**From:** Anita Gardner  
**Sent:** 28 November 2018 12:48  
**To:** Planning.Responses  
**Subject:** FW: LU/223/18/pl 36-38 Surrey Street, Littlehampton

**From:** Anita Gardner <[Anita.Gardner@arun.gov.uk](mailto:Anita.Gardner@arun.gov.uk)>  
**Sent:** 24 October 2018 14:52  
**To:** Emma Weaver [REDACTED]  
**Subject:** LU/223/18/pl 36-38 Surrey Street, Littlehampton

36-38 Surrey Street, Littlehampton,  
West Sussex, BN17 5BH

Proposed Floor Plans

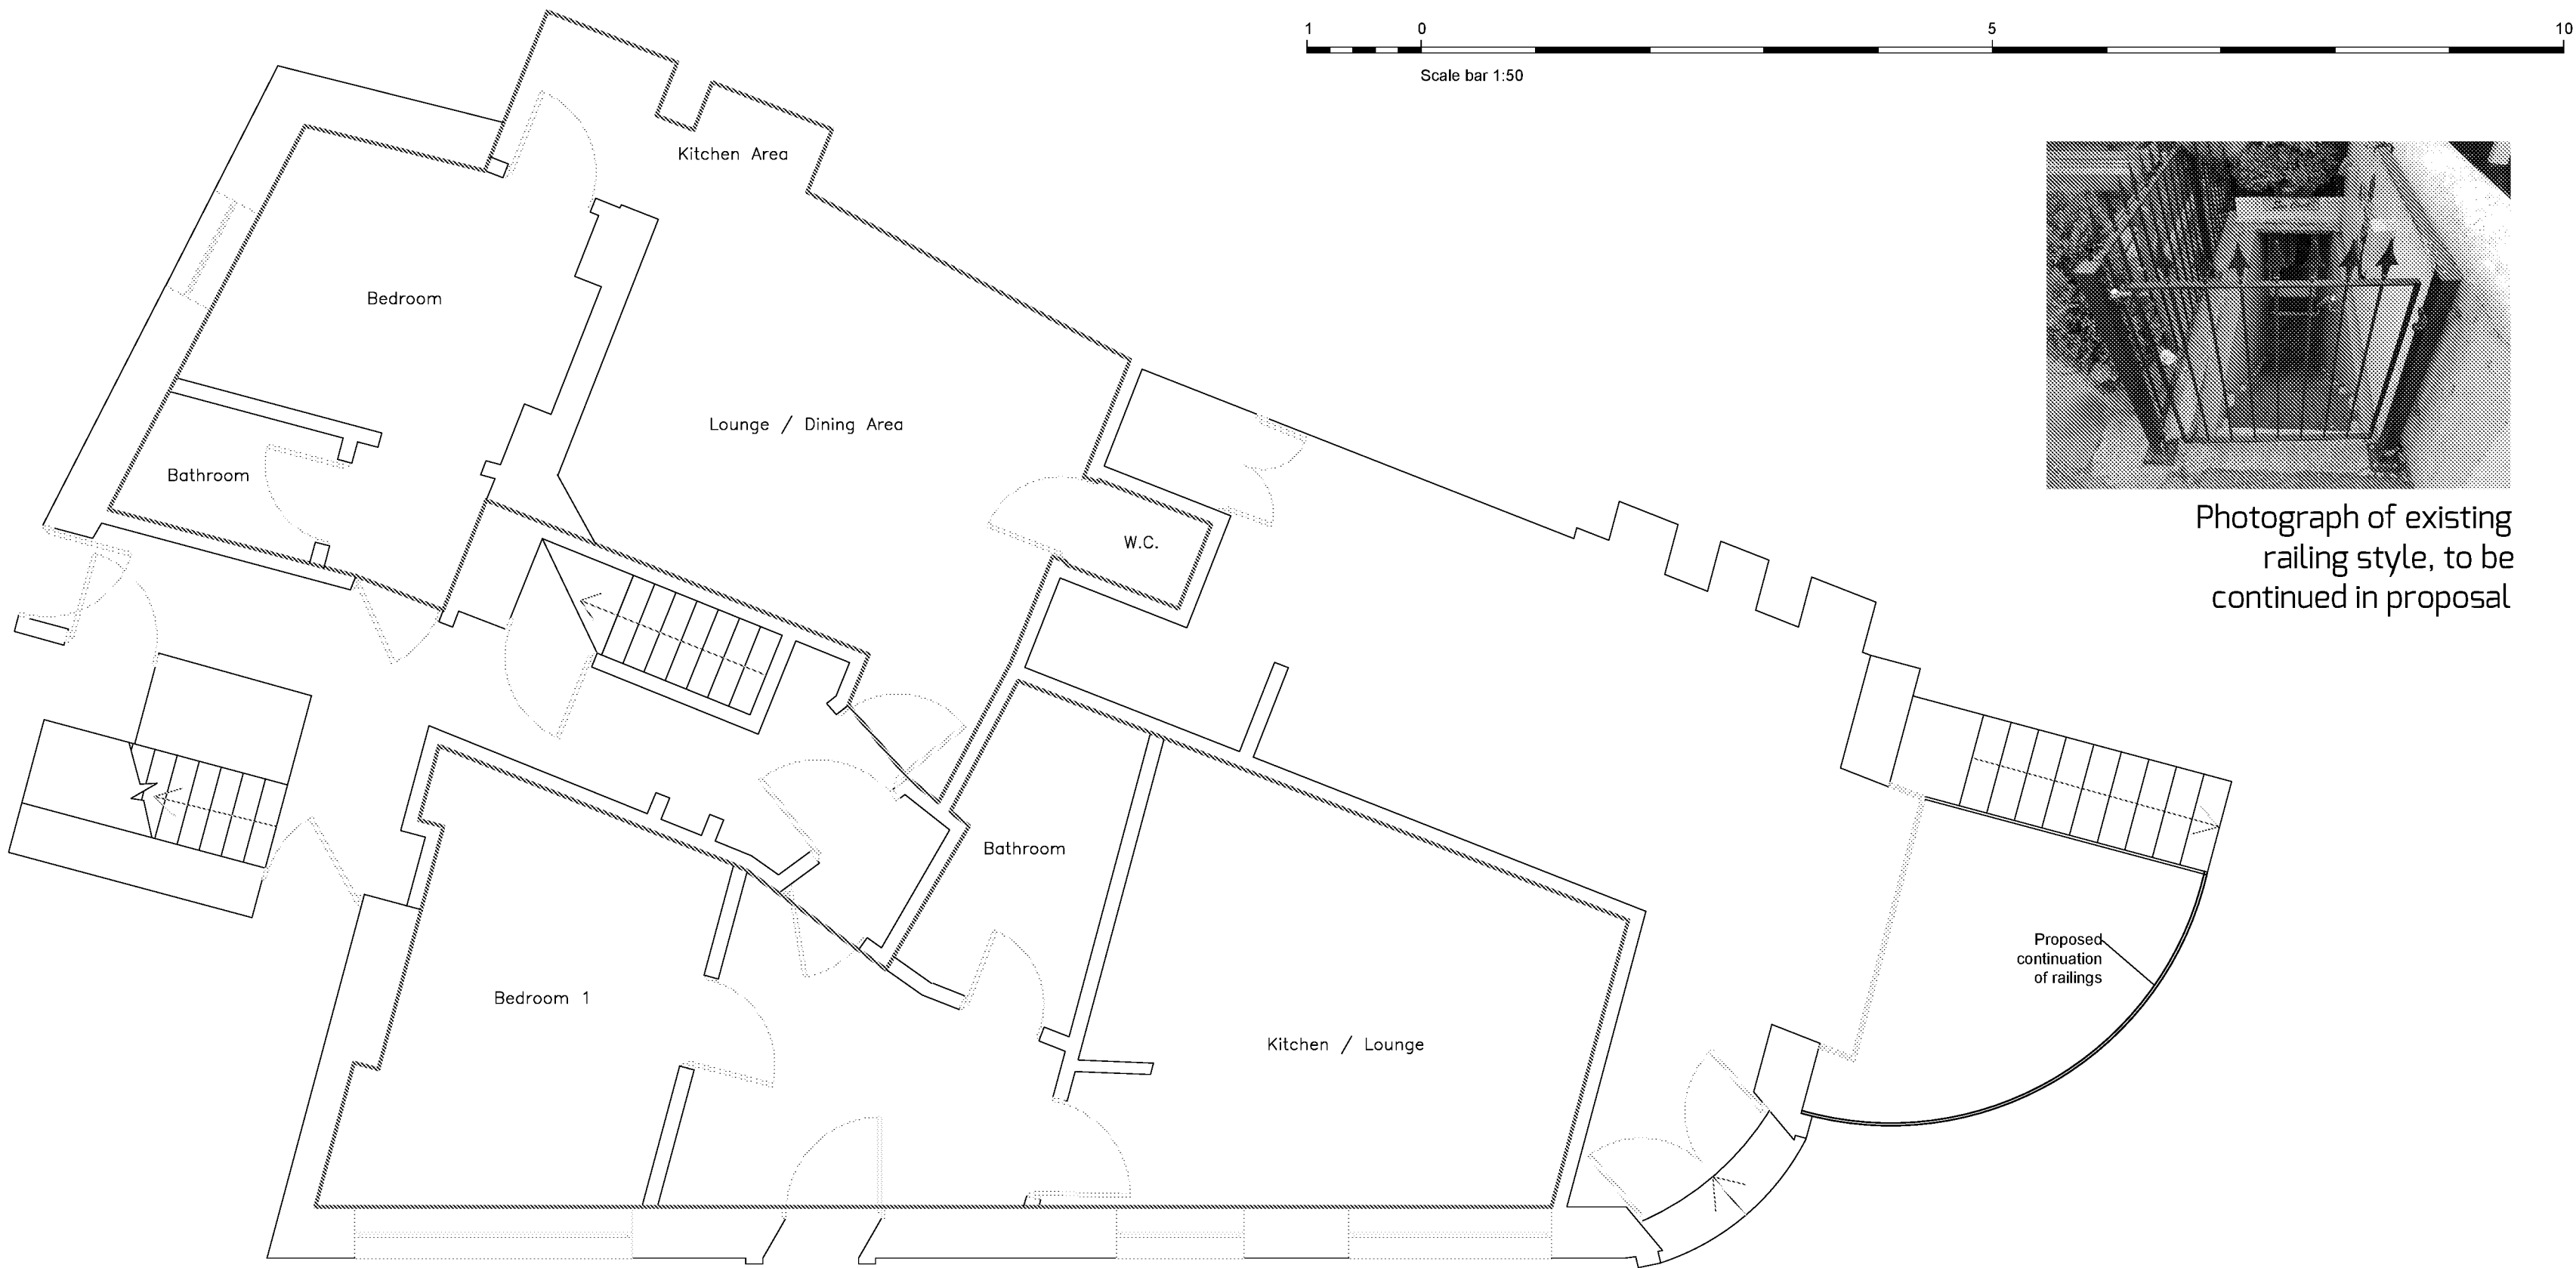
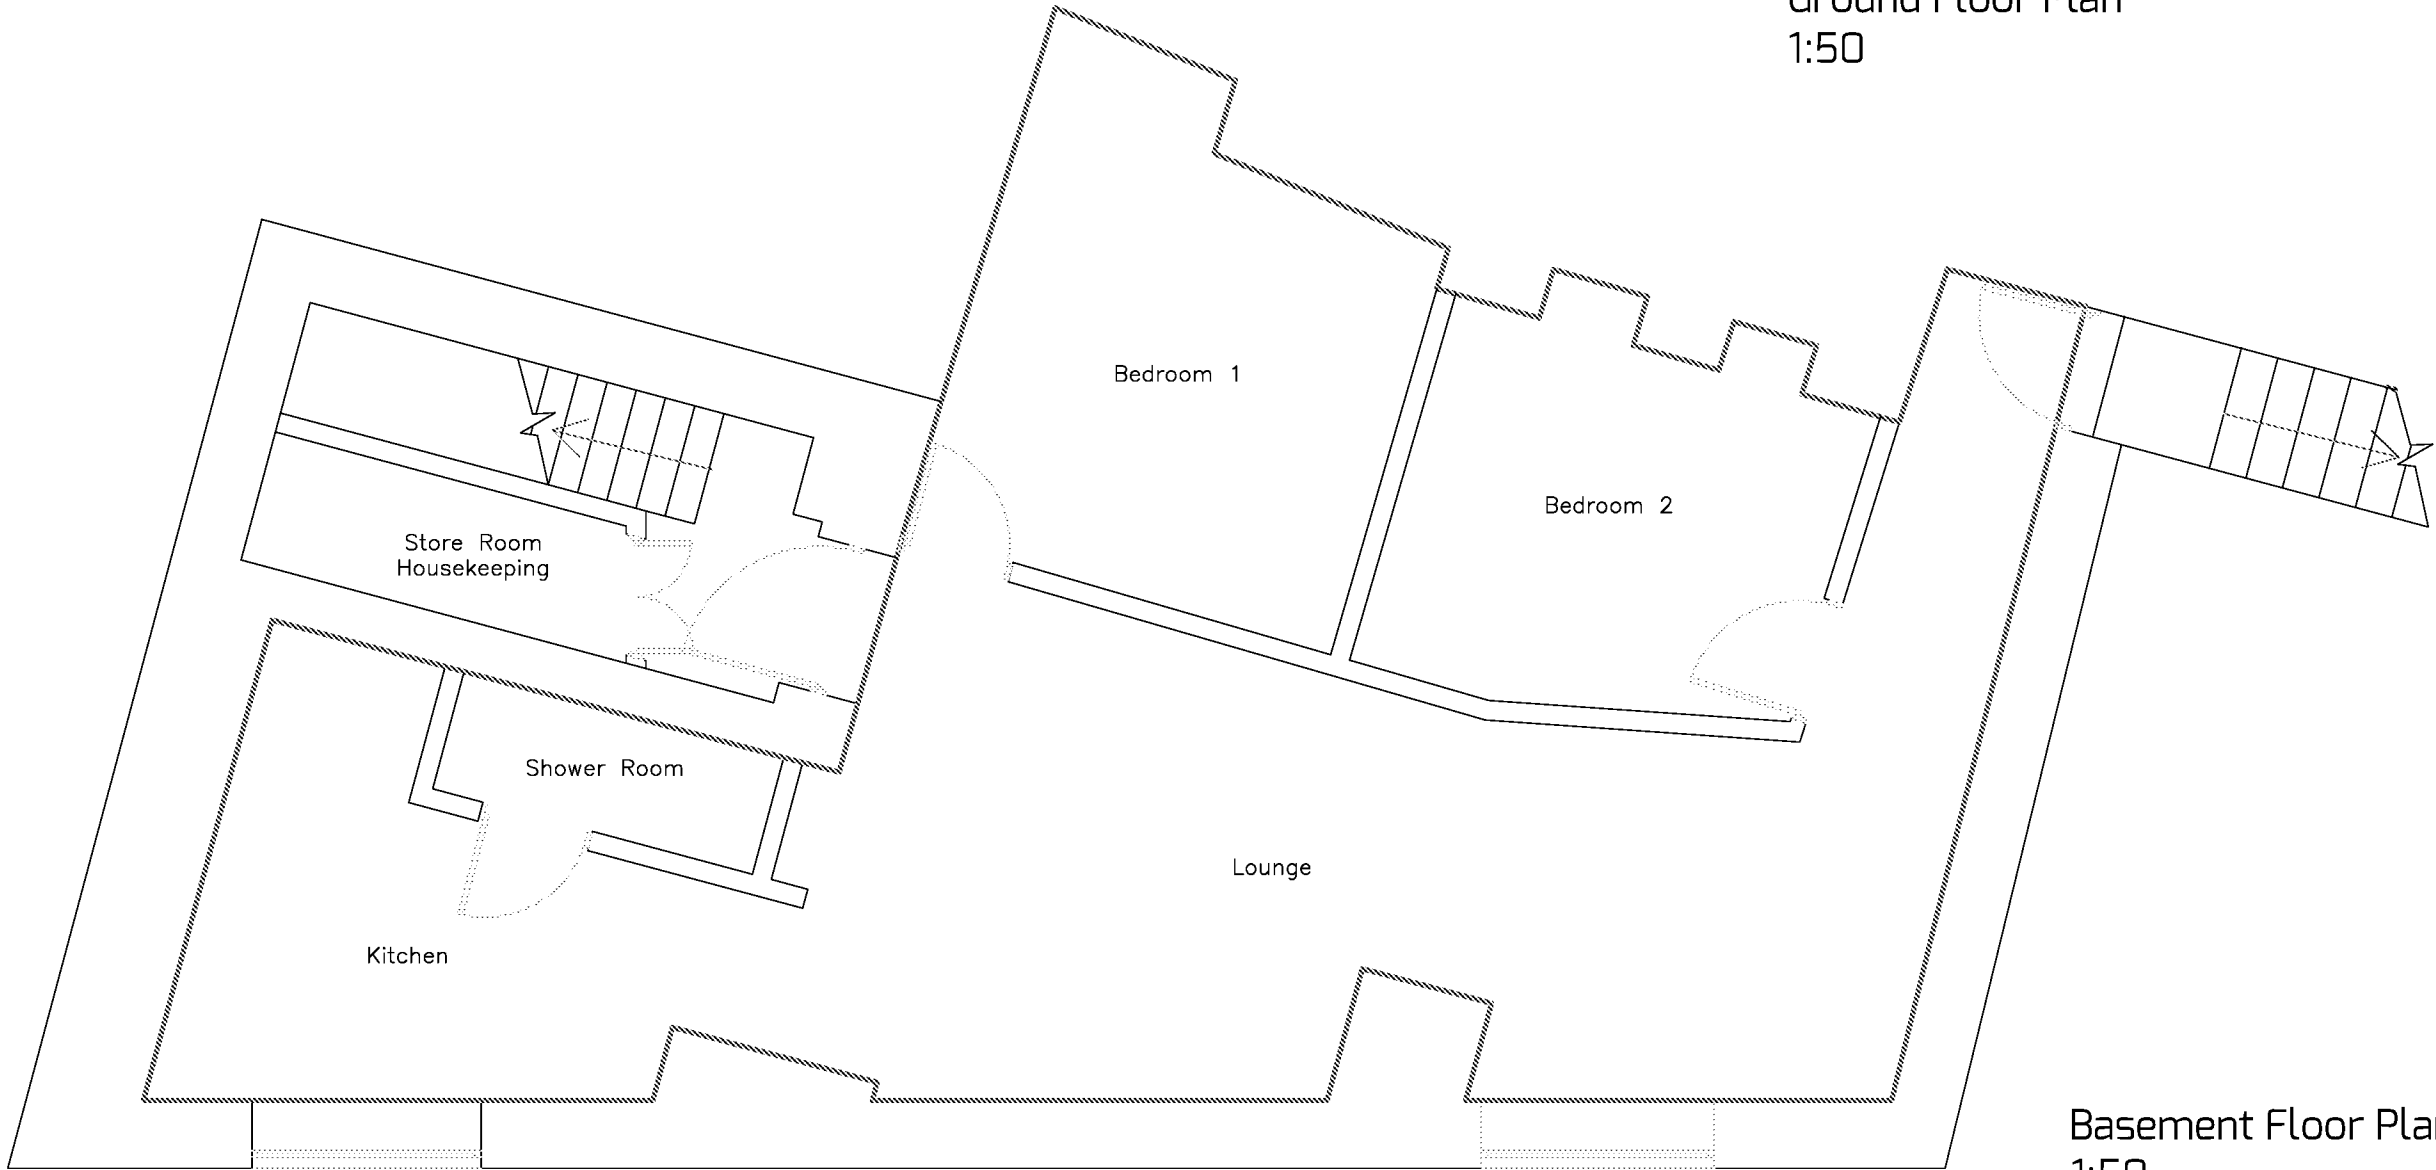
I also note that the railings at ground floor level are not included in the application description and if they remain part of the application the description will need to be amended to include them and submission of further details and discussion with the Conservation Officer will be required. This alteration may require re-advertising.
